Article 21 of the Town and Country Planning (General Development Procedure) Order 1995
Application for approval of details reserved by condition 3 of previously approved planning
application AB/117/12 - construction/operation mechanism and materials of all new joinery
The Old Bakehouse 27 King Street, Arundel,

Arun District Council have decided to **REFUSE** details reserved by condition for the following reasons:

Revisions:	Client:	TUNMORE DESIGN	w: www.ashjoineryttd.co.uk e: www.info@ashjoinery.co.uk t: 01903 776333 f: 01903 776234
	Project:	27 KING STREET, ARUNDEL	
	Drawing Title:	CASEMENT WINDOWS	
	Drawing Number:	13/01	
	Scale:	1:1 @ A3	
	Revision:		
	Date:	08/04/13

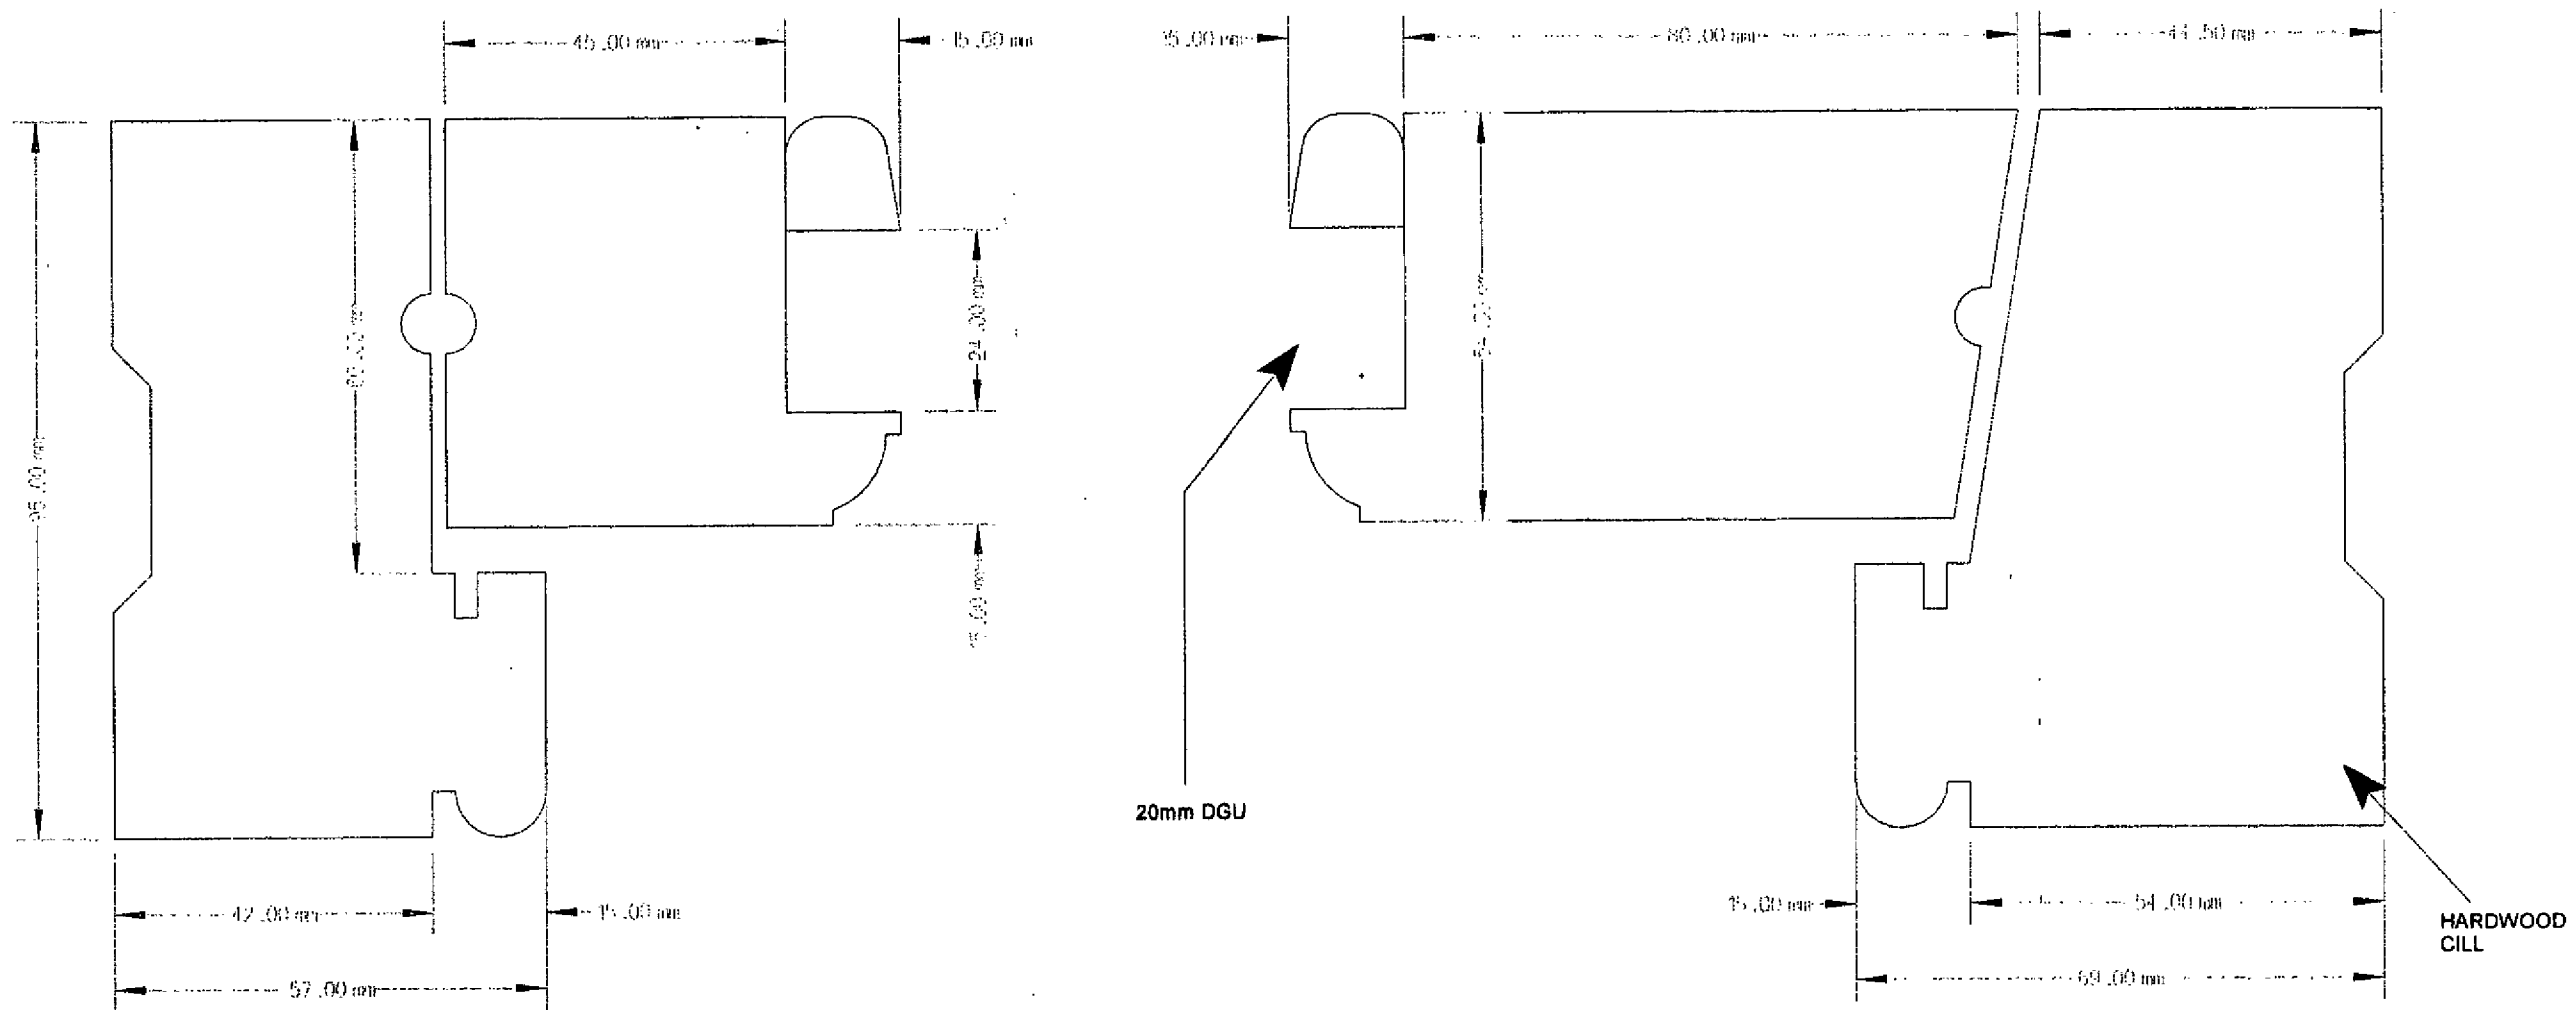
The window details shown on drawing 13/01 are not acceptable for the small window. The bedding is inappropriate. The profile should more closely reflect putty and have a traditional less obvious appearance between the glazing. The details may be acceptable for the doors, but this is not specified and there are no mechanism details included with the application.
